Application Reference: 2026/0242

Site Address: 13 Wellhouse Lane, Penistone, Sheffield, S36 8ER

This application seeks planning permission for the removal of existing single storey garage, side store and utility, and replace with erection of 2 storey rear extension to dwelling

6 Proposed First Floor Plan
1 : 100

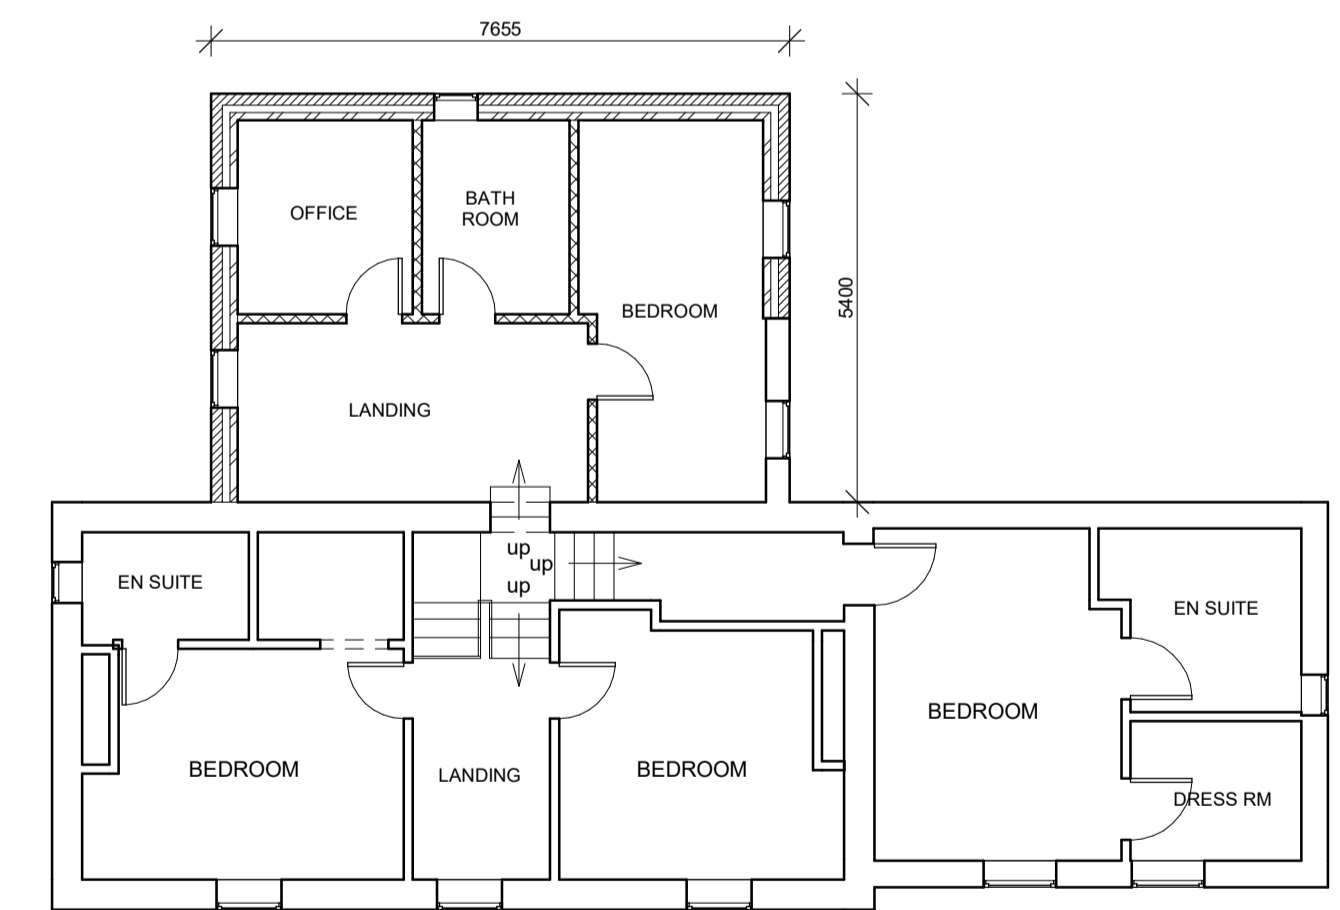
The proposed two storey extension is to be located on the northern elevation and would not significantly increase levels of overshadowing of neighbouring dwellings. The plans have been amended during the course of the application, in order to alter the internal layout at first floor level and to reduce the size of the extension due to build costs. The amended proposals mean that there are no habitable room windows on the west elevation at first floor level to avoid any overlooking of the garden of the adjacent dwelling to the south west, number 13b. The window at ground floor level will be screened by boundary treatments.

Alteration to internal layout to remove first floor habitable room windows to the western elevation.

PROPOSED BACK ELEVATION

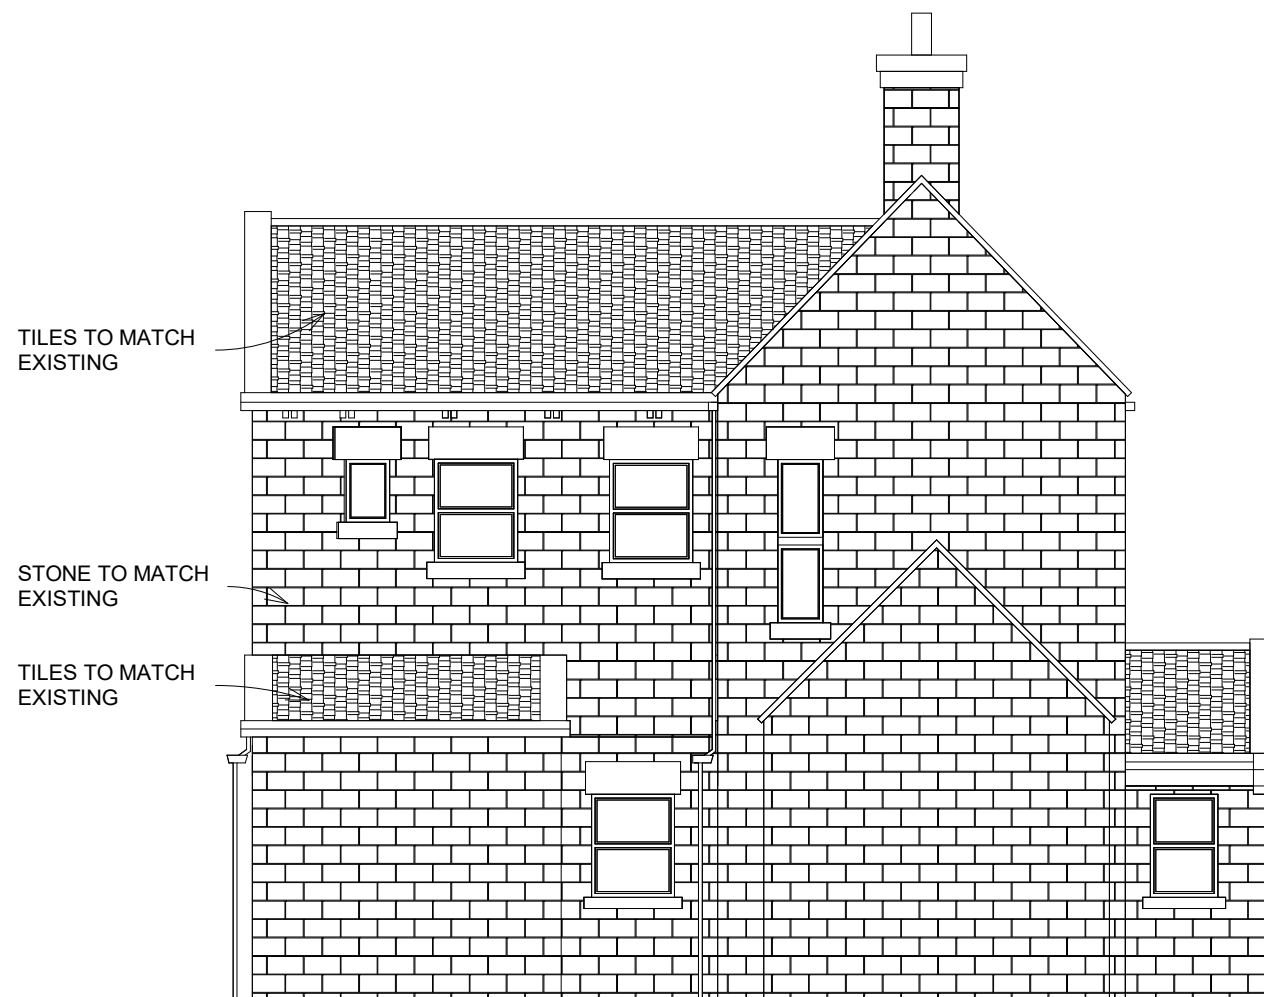
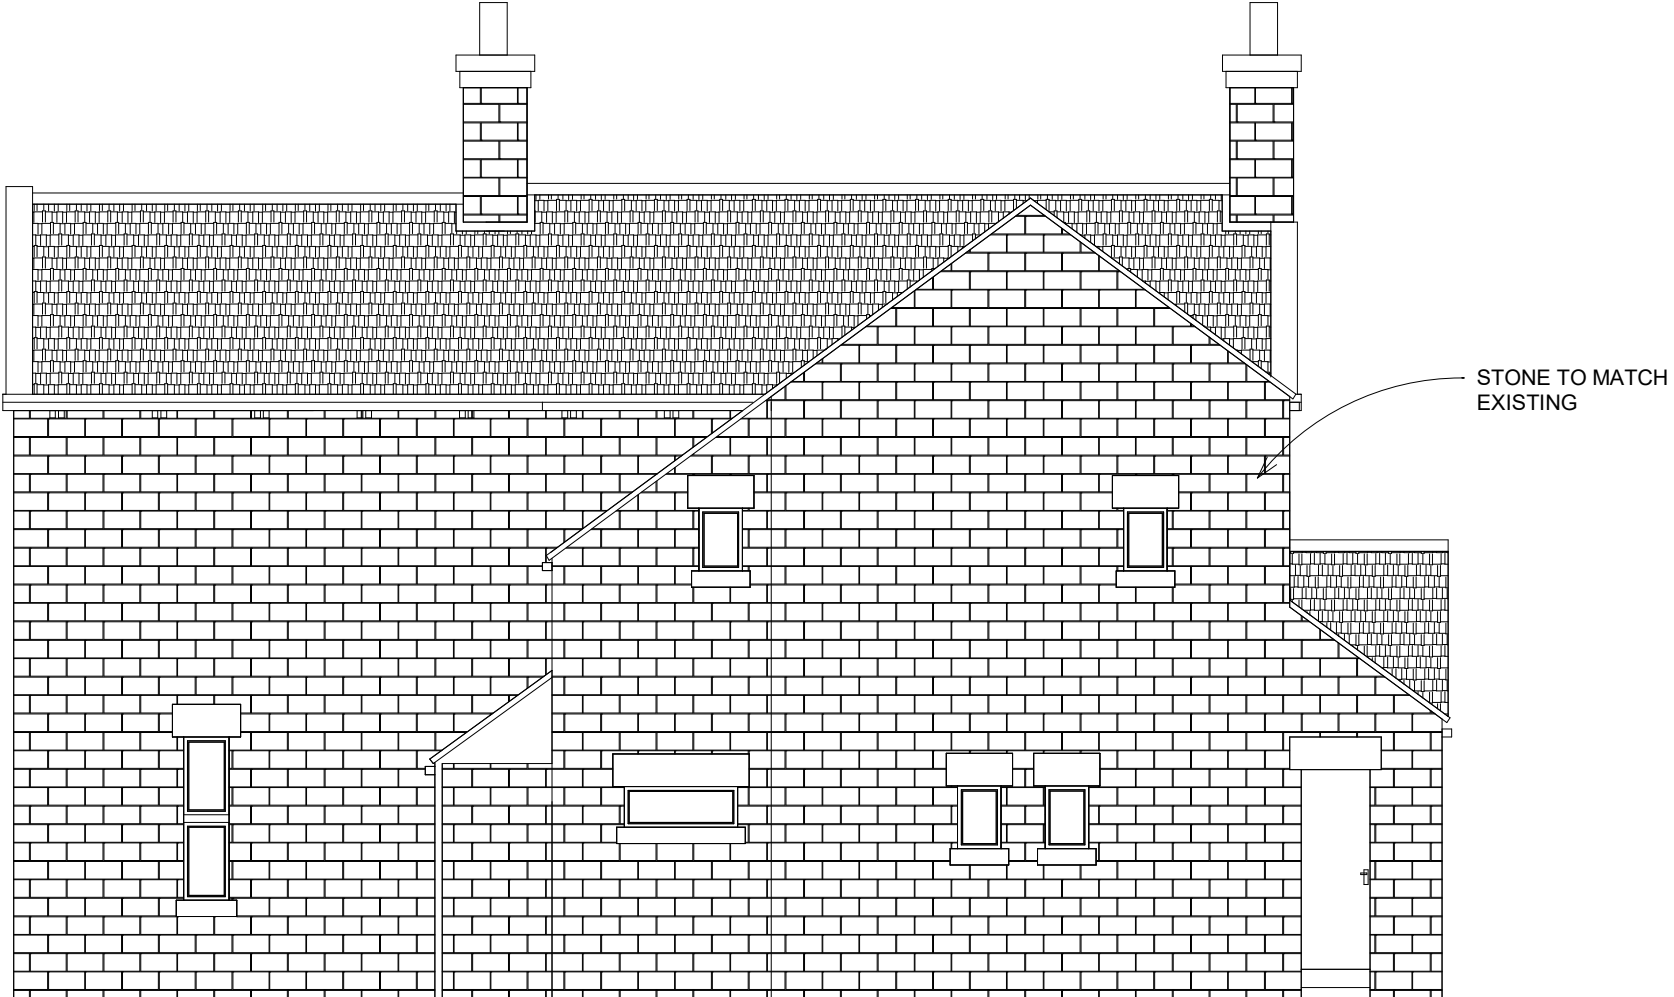
There are small windows proposed on the northern elevation, which include a small secondary window to a bedroom and an ensuite. These windows would face over the front garden to 13a, however given the small size of the windows and that the window to the bedroom is a secondary window, there should not be any significant overlooking of private garden areas or direct views to the windows of number 13a.
